Topic	PF Response
WSCC response and questions	
1. Design speed – This is still quoted as 30mph. However, no reference to the WSCC Speed Limit Policy is provided. As such, the applicants should set-out whether-or-not the new A29 road accords with that Policy.	The Design of the A29 is seeking to align with WSCC Speed Limit Policy, however it should be noted there are some outside influences which has impacted and shaped the design process. Further to various meetings with WSCC on the road design in 2019 and 2020 and prior to the submission of the Planning Application there was an agreement between WSCC highways team, WSCC A29 delivery team and The Southern Consortium that the A29 would be subject to a 30mph design speed. Reference to these discussions are highlighted in our Design Statement. In line with WSCC Speed limit policy the main elements are, the road will need to demonstrate that any design speed chosen is self-enforcing and this will be influenced by design speed related parameters but also by the road width, alignment and layout constraints (number and type of junctions, pedestrian crossings, frontage activity, accesses, bus stops and level of frontage development and asso

Drawing Title
**INITIAL BRIDGE OPTIONS
MULTI SPAN**

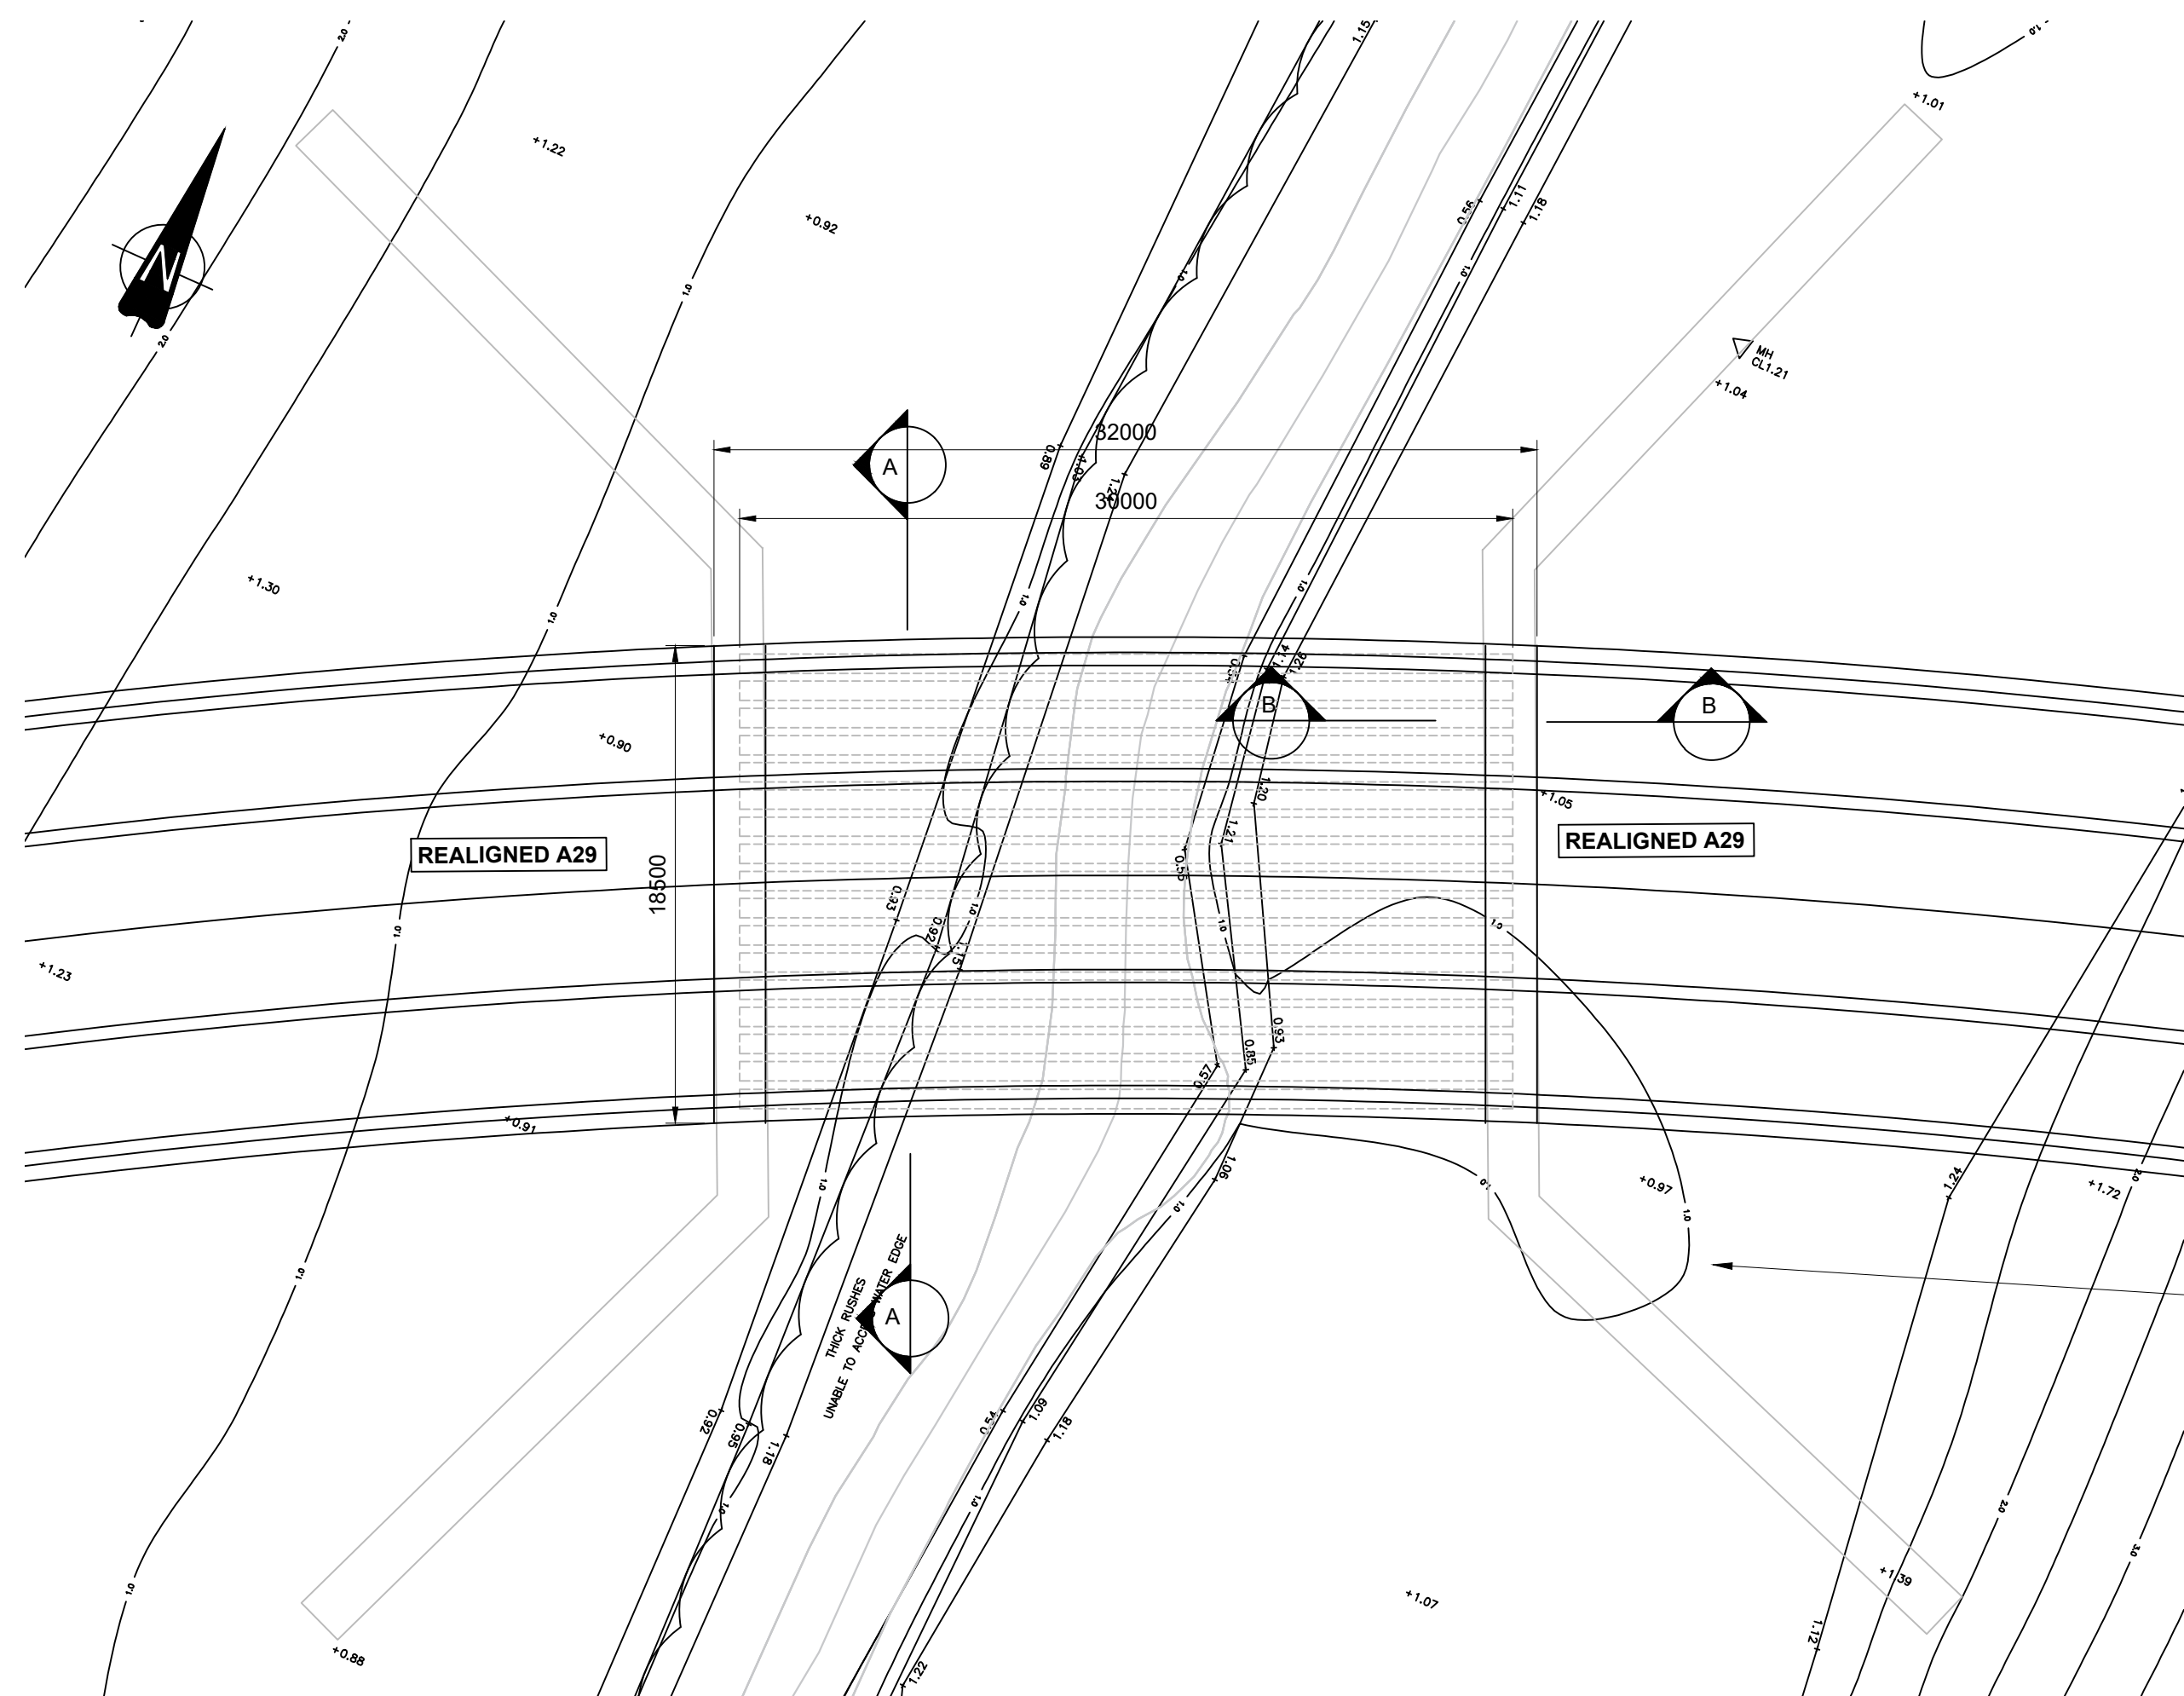
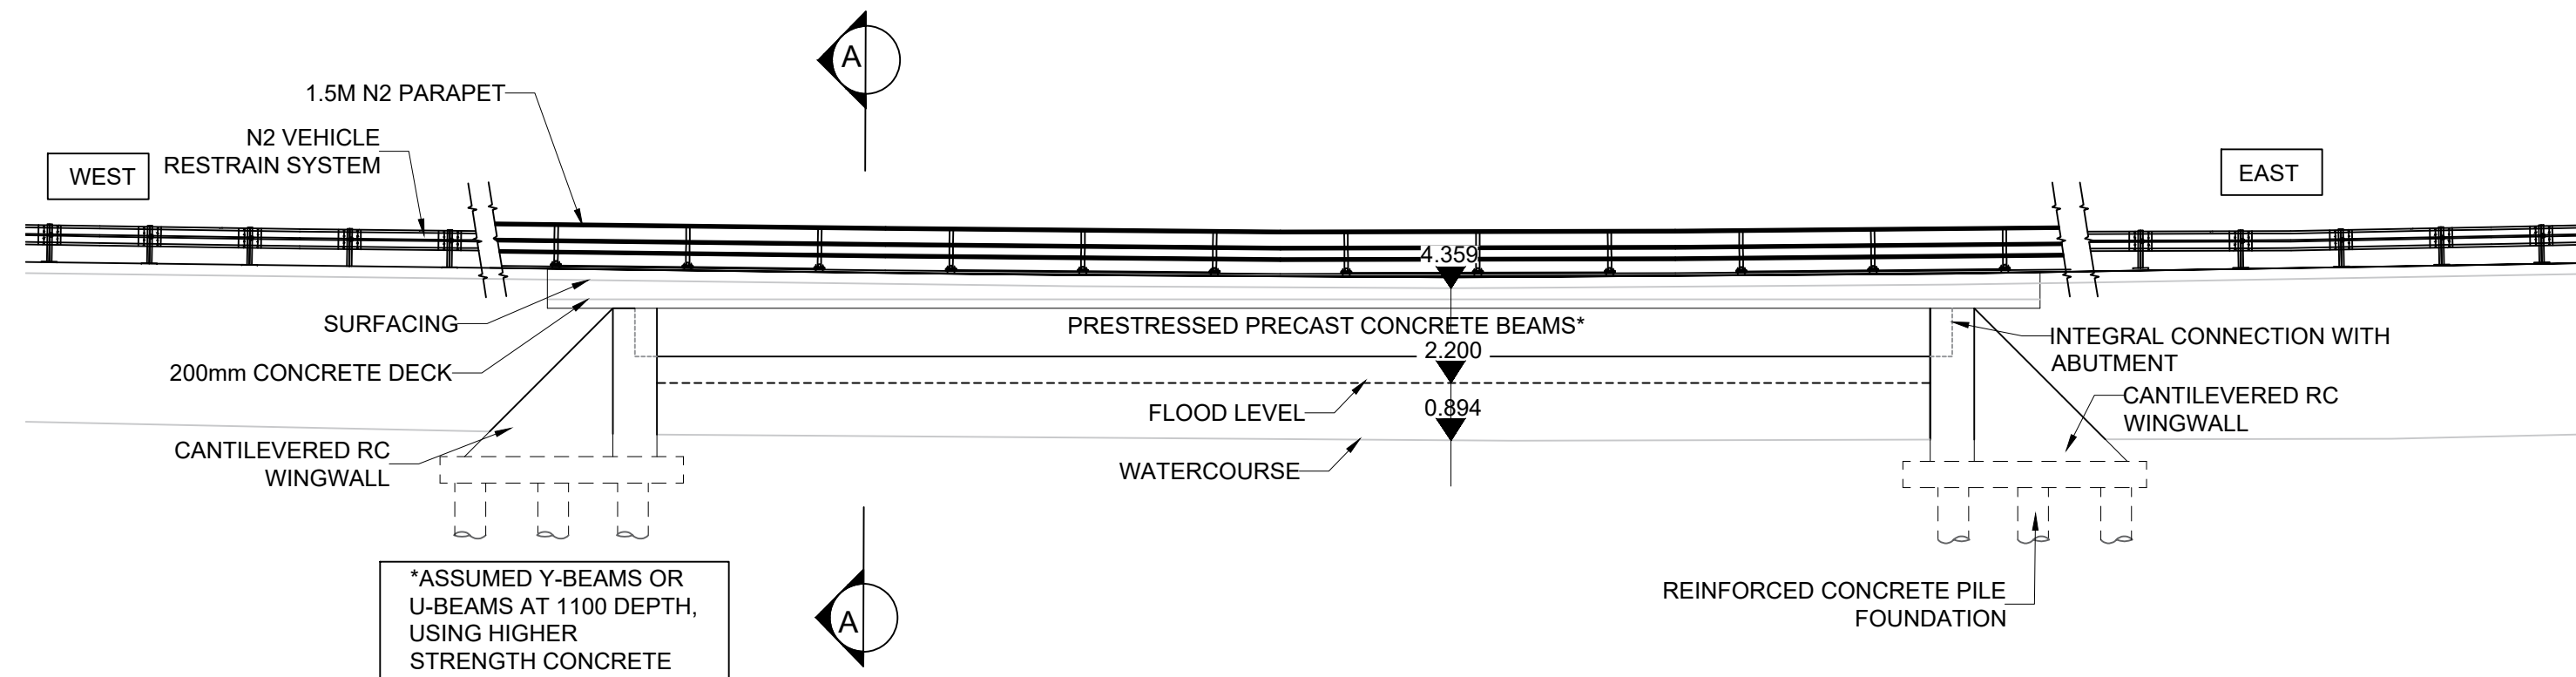
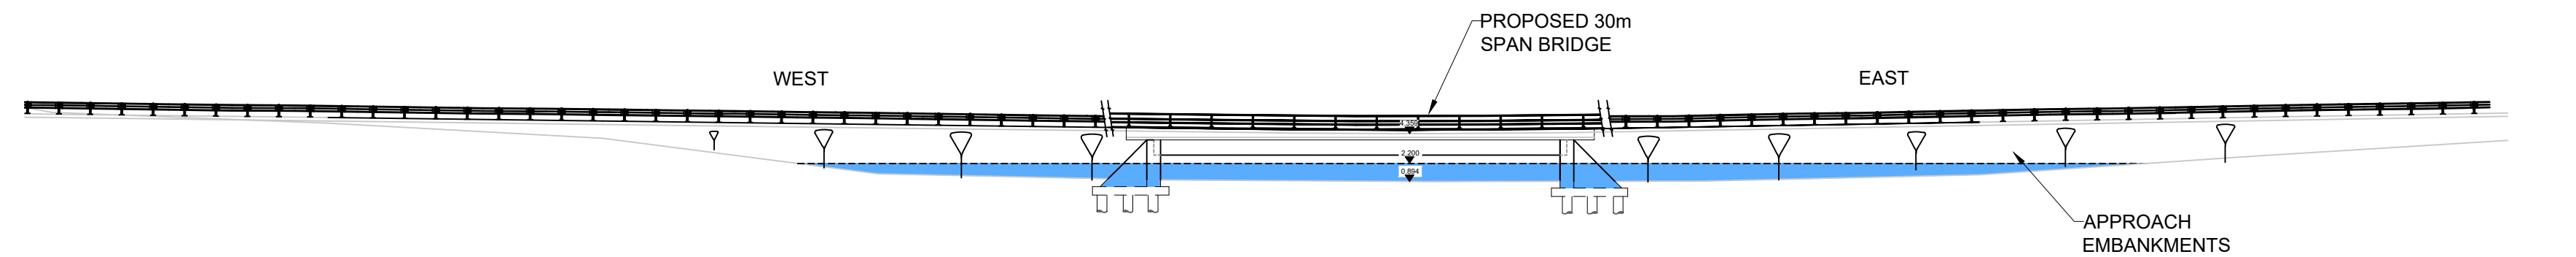
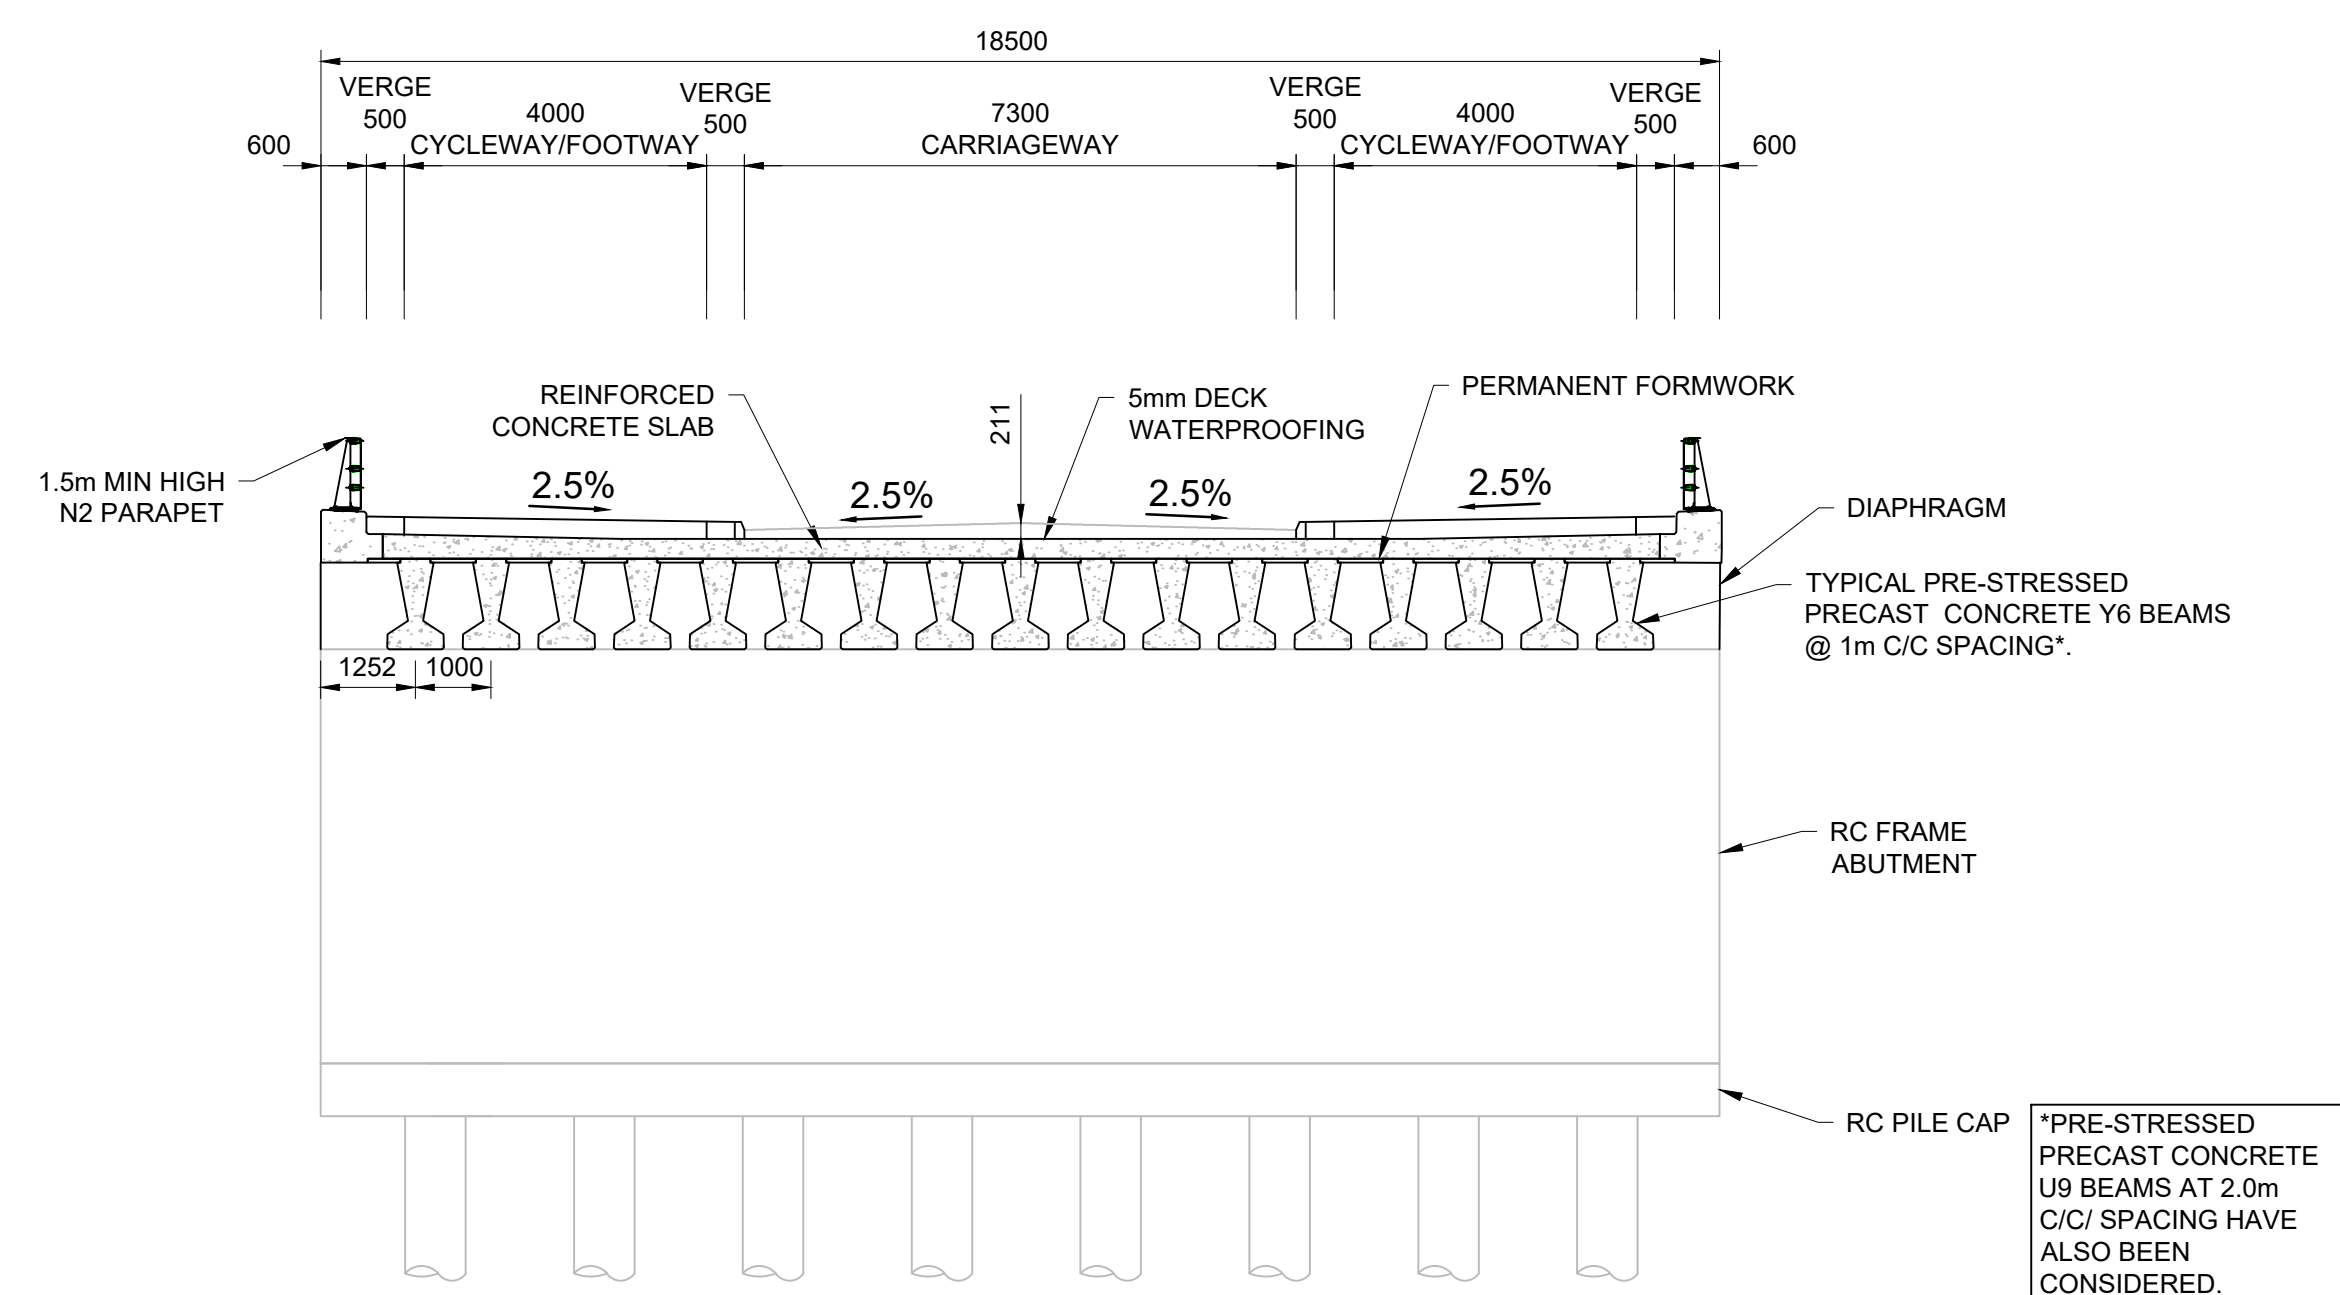
The Technical Note (TN) is geared towards either a) a 200m long multi-span viaduct, or b) a 30m single span structure. The reason for the massive variance is as stated in the front of the report, see screen grab below.  However, recent discussions with the Environment Agency have reduced to the flood level to 2.2m AOD at point of crossing. As a result, the structure clearance can be reduced and therefore the multi span bridge is no longer a viable option. For information purposes, the multi span structure proposal is included within this report. Given as much, the vast majority of the content of the TN is of limited use as it only discusses 1No. viable option. The TN should have addressed various single span options (e.g. weathering steel, U or W beams similar to the Options Report for the rail bridge). As a result, the drawing is certainly of interest but also of limited value (in the context of 'options'). Perhaps the rife bridge could basically be a repeat of the rail bridge (the widths should be identical and the spans are very similar)?	Technical Note updated as required.

c. It is appreciated that deeper beams result in more fill on the approaches, but with Y6 beams at 1.0m centres there is not enough space between the beams to inspect the inside faces (gap is currently approx. 250mm). Deeper beams at larger centres are necessary.	Changed from Y6 to Y8 beams at 1.2m c/c. Alternatively W13 beams at 3.25m c/c are included in the technical note.

d. The cantilevers look too wide given how thin the deck slab is(?).	Cantilever reduced due to new Y beams and changes to the highway section.
e. Typically with a Y beam deck there are YE beams.	YE beams added.

f. Ideally, WSCC would require inspection & maintenance access points to the underside (steps down the embankments at diagonally opposite corners?).	Access for routine inspections and maintenance to be incorporated in the design at a later stage.

g. The report touches on the lack of clashing with existing services, but what about new services? There is not a lot of fill to accommodate larger diameter mains. It is appreciated that this is the first submission but WSCC would like to see something on the drawing that is indicative and calls up that the utilities are TBC.	Drawing updated to indicatively show new services within the footways of the bridge. Specific requirements to be confirmed during consultation/enquiries with Statutory Authorities (Utilities).
